Sent: 26 January 2024 15:34
Subject: 2023/93704 land northwest of urban Terrace

Assistant Definitive Map Officer

PROW PLAN

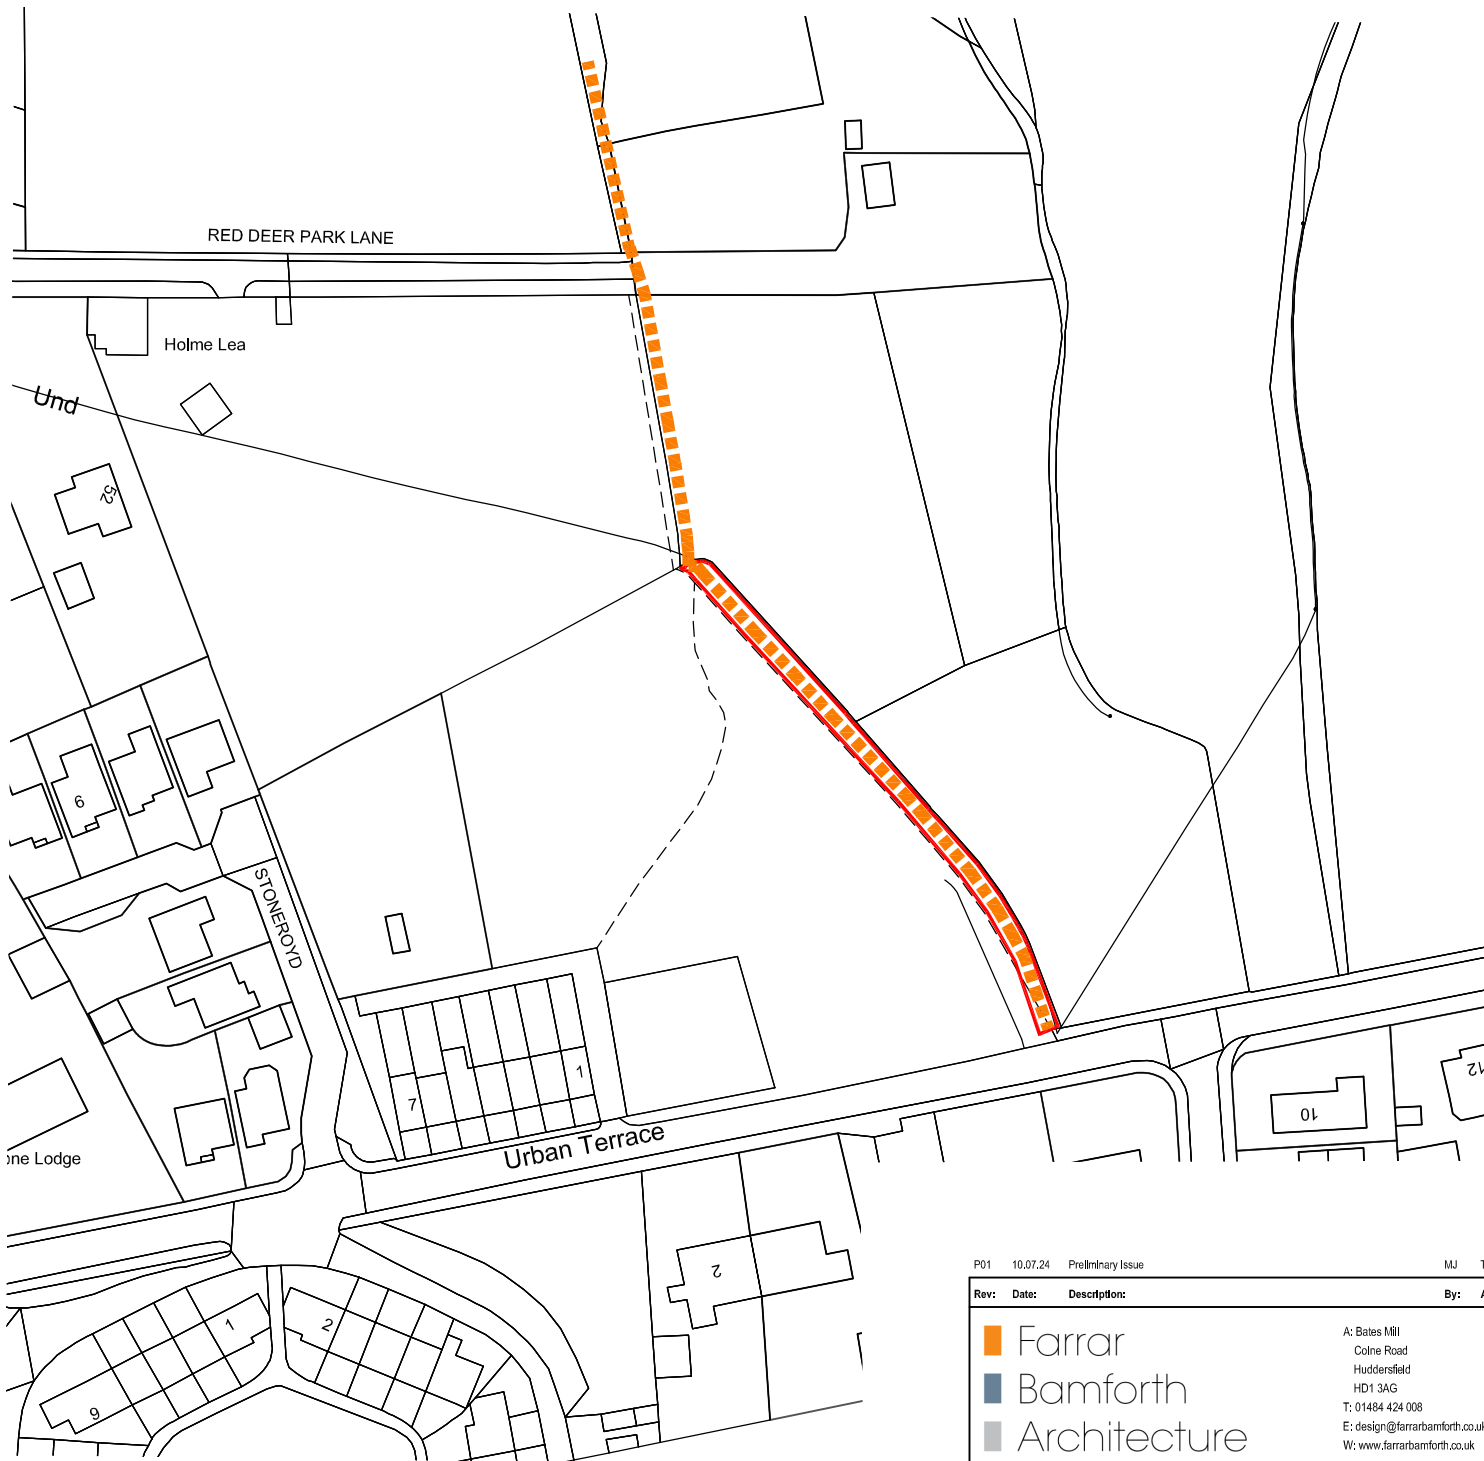
The application gives no details of the footpath which is within the development site other showing it has a line and indicating it is 1.5 m width. Prow would insist on a minimum width of 2 m especially as the proposed design indicates that the adjacent land will be developed and the adjacent land is within the LP development site

Prow would wish to see sections, cross and long including the path, details of the boundary fences, surfacing and any path improvements
